Response to Submissions

ACP-324082-26

Response to Submissions on behalf of Drumkee LCIS Limited

Case Number Reference: ACP-324082-26

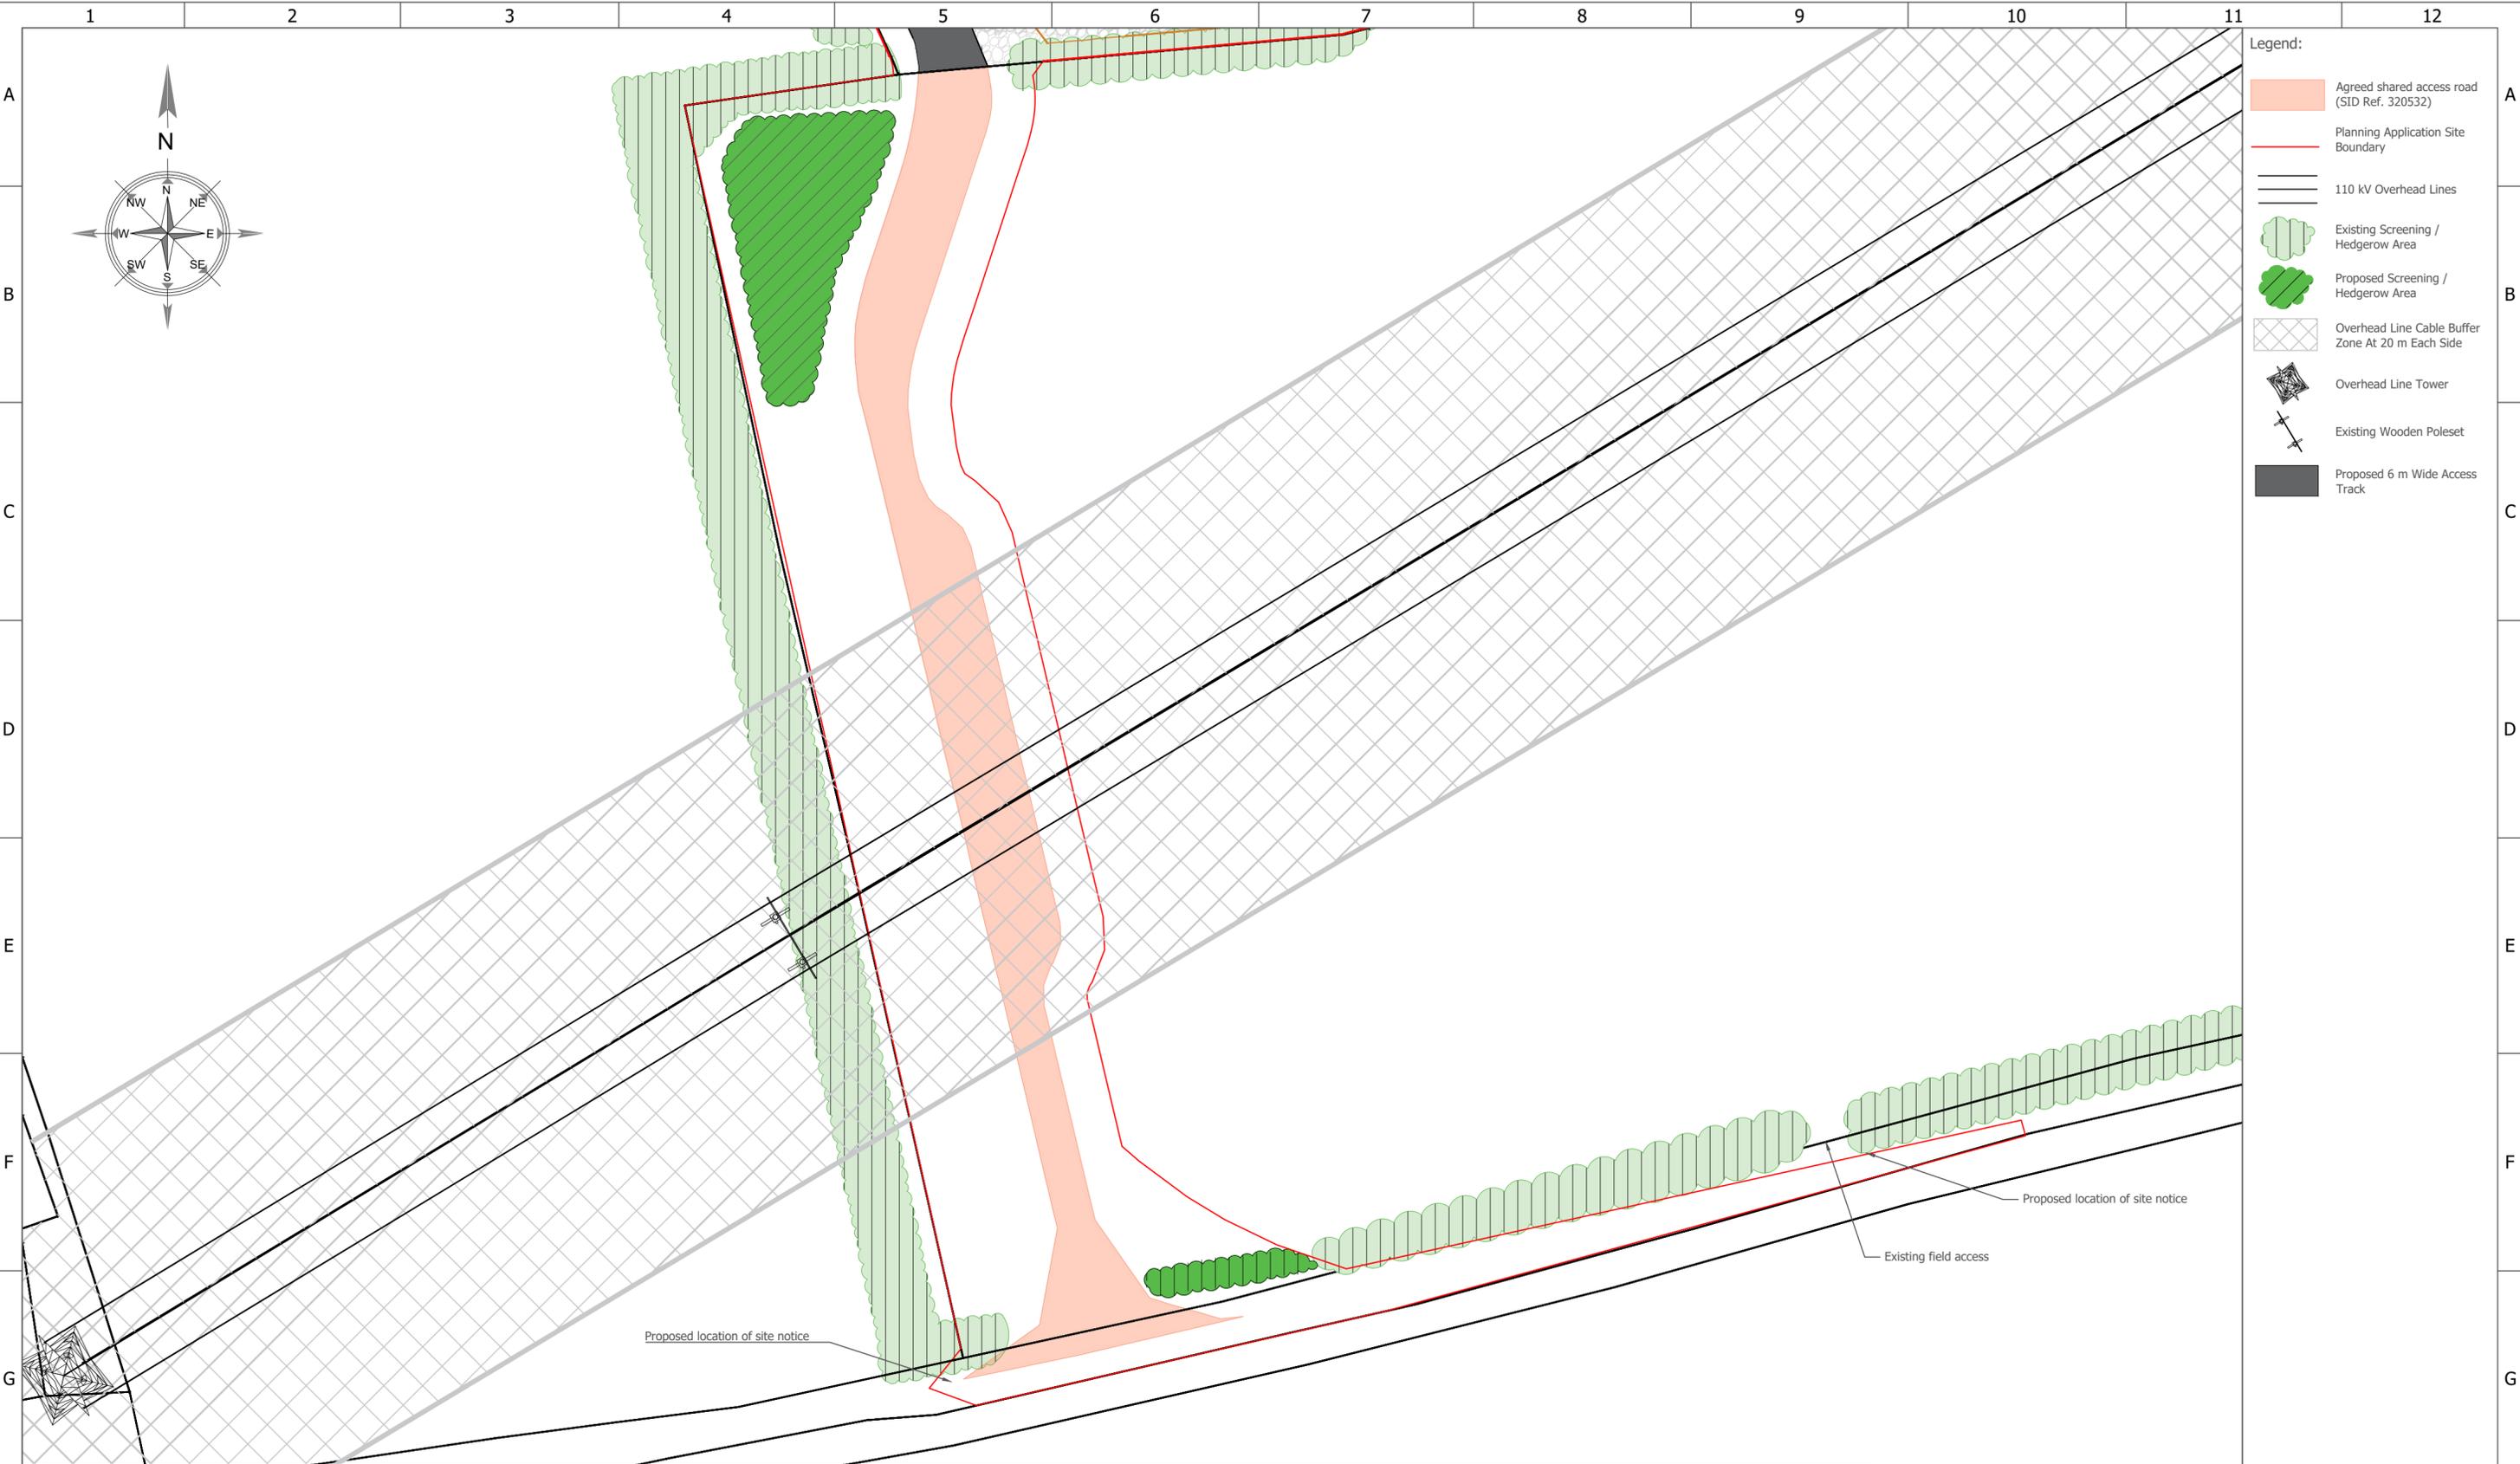
One third-party observation raises concern over the location and spacing between individual BESS units.

Information has been quoted in an observation referencing minimum distances from the perspective of fire safety and the risk of containment to a single unit. The applicant has presented a site layout of the proposed development which pairs battery container units with no visible gap between them, therefore raising the question of spacing in the unlikely event of a fire starting and spreading beyond an individual battery unit.

Section 7 of the Fire Strategy Review Report details individual container spacing which is NFPA 855 compliant.

The separation distances between the container pairs is shown to be 3 m in the planning drawing titled "Site Layout - Map B". While the individual units in the pairs are less than 3 m apart, there is a note in Section 7 of the Fire Strategy Review Report that states: "*The BESS system designer adopts IEC 62933-5-2, which aligns closely with NFPA 855. The spacing requirements must be supported by performance testing in accordance with UL 9540A. Although NFPA 855 provides prescriptive spacing criteria that are not specified in the IEC 62933-5-2, it allows the system designer or manufacturer to utilise higher battery energy capacities with reduced spacing, provided that UL 9540A testing demonstrates thermal runaway containment and the absence of further propagation. The system designer has agreed to comply with these requirements and to provide sufficient test data at the detailed design stage.*"
